**Consultation Response from Alan Smith,
KC Waste Strategy (Refuse & Recycling)**

2025/90241 14, Firth Street, Huddersfield, HD1 3BA

**Variation of condition 2 (plans) on previous permission 2023/93782 for erection of extensions
and alterations to form 16 student apartments**

Responding Ref: WPS 25 021

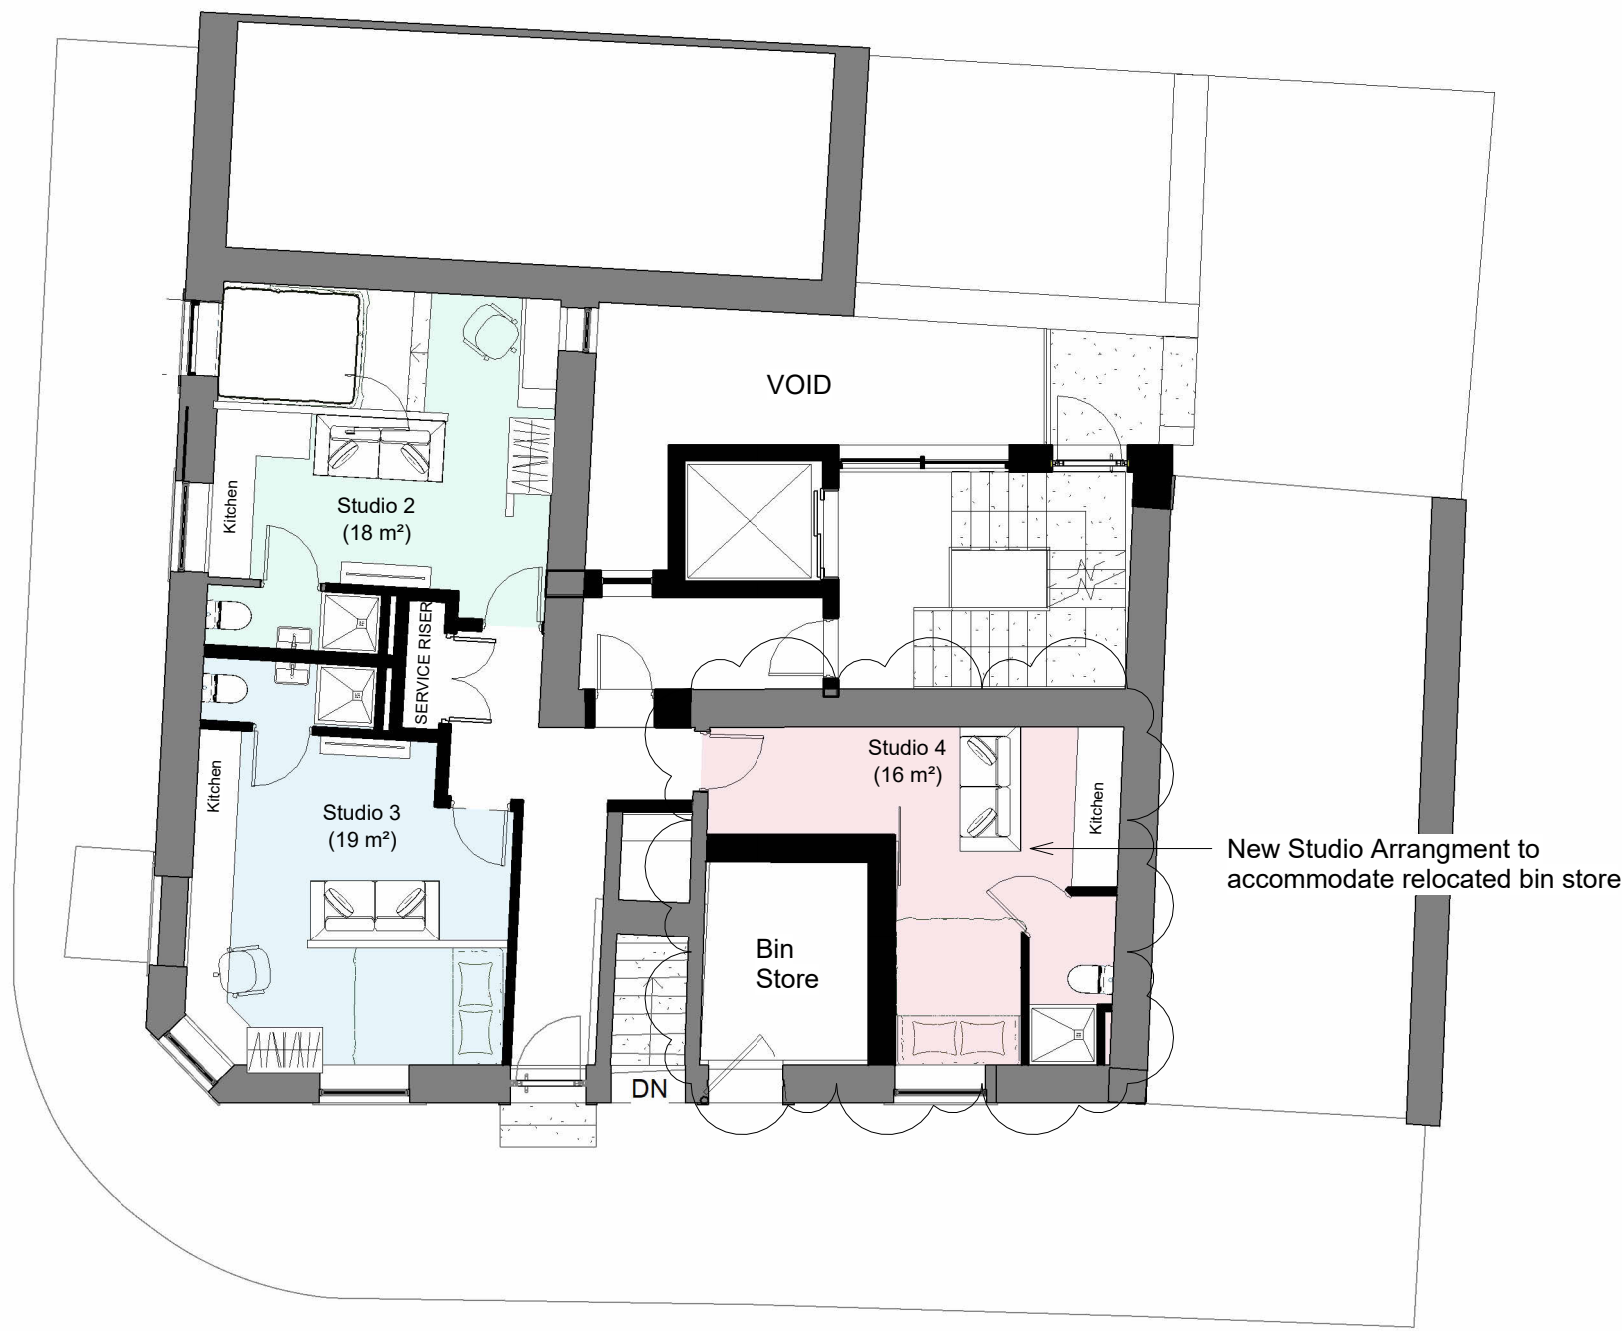
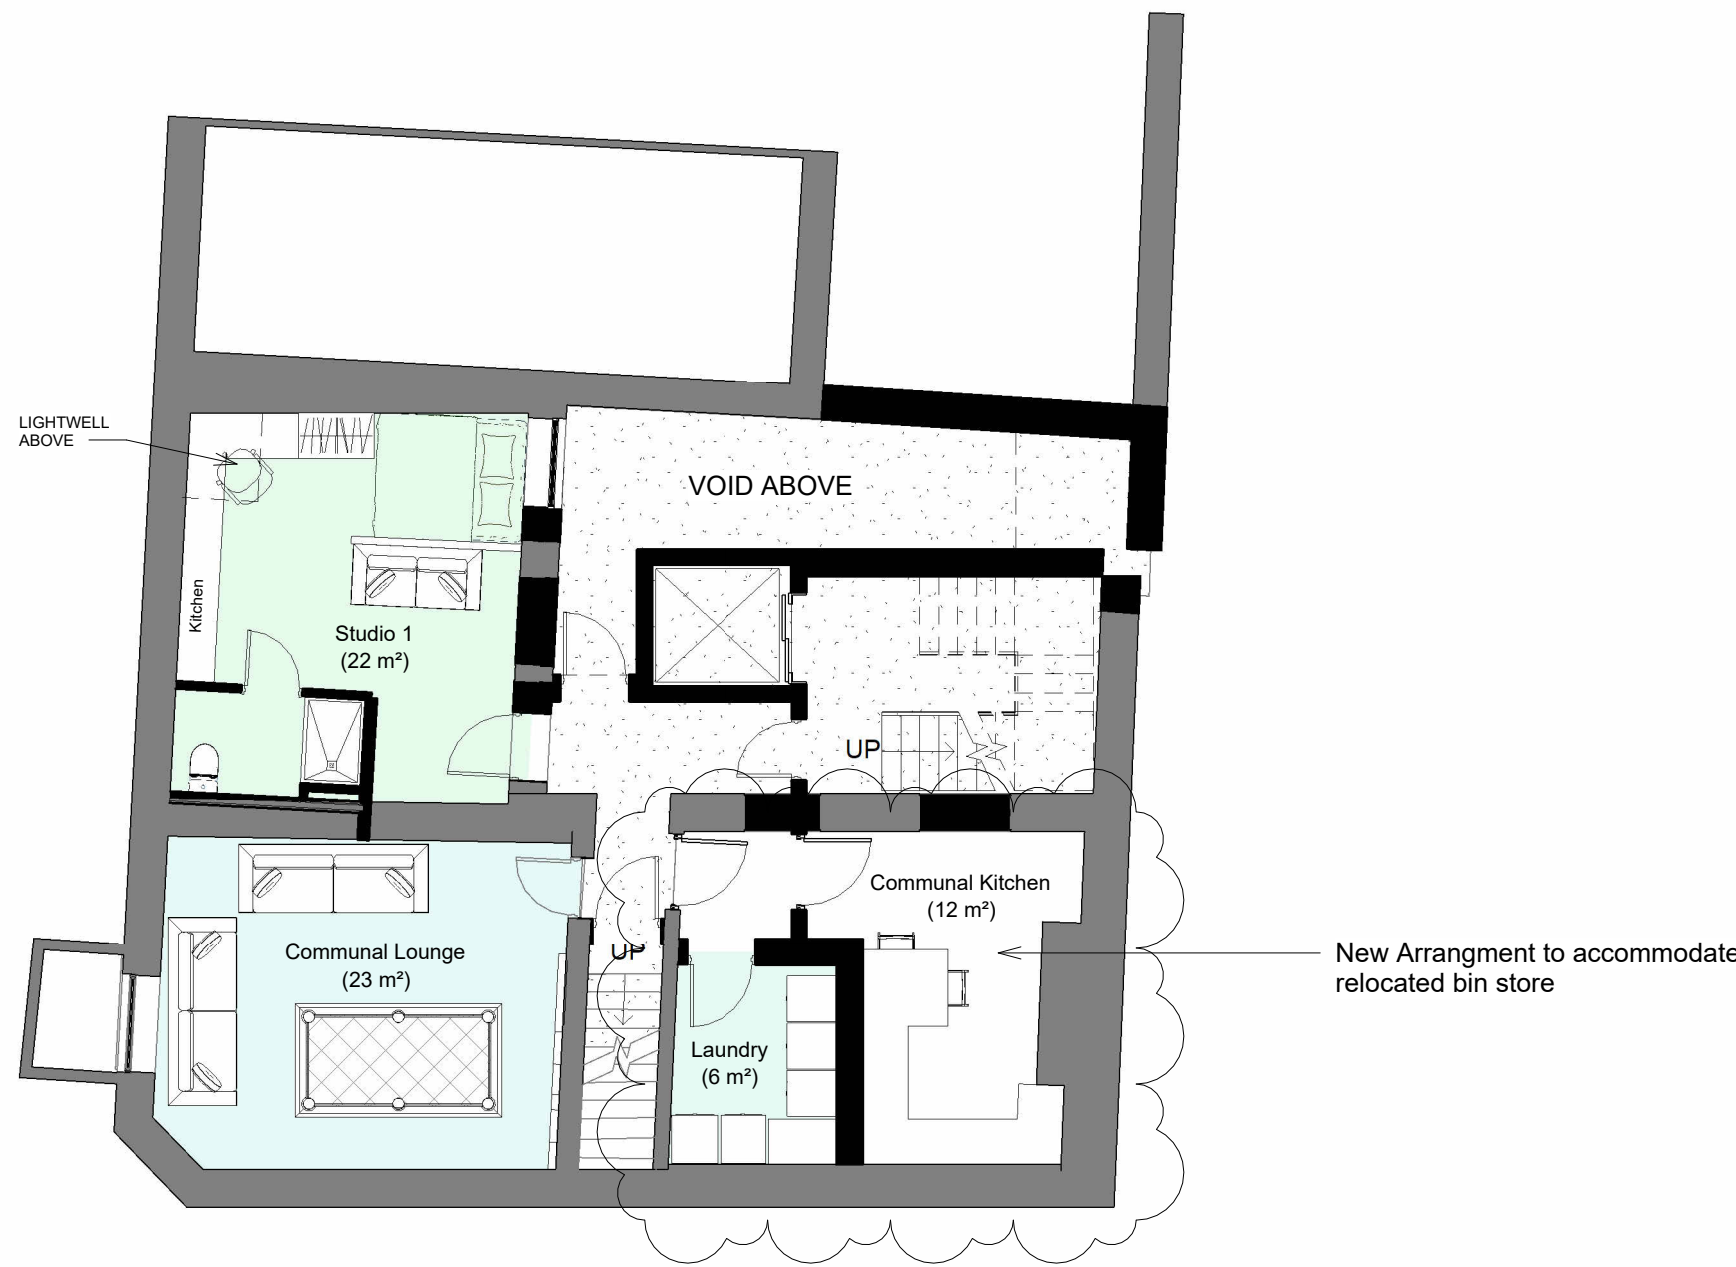
It is noted that the bin store has been redesigned as show in the drawing below.

- The bin store entrance will be level with the highway so there is no slope or lip to move the bins over for emptying.
- The bin store itself is big enough to accommodate 3 x 660ltr wheeled bins, 2 of the bins being for residual waste and 1 for recycling.
- A property management company will be responsible for manoeuvring the bins out for collection on the correct day and return them, so they are not left on the highway.
- The bins will be collected by a private waste management company which will empty the bins as frequently as necessary, likely to be at least twice per week.

The Council's preferred option would still be for the collection of waste from the courtyard to the side of the development on Firth Street. However, these proposals meet with our requirements for waste storage and collection and are acceptable to the Waste Collection Authority.
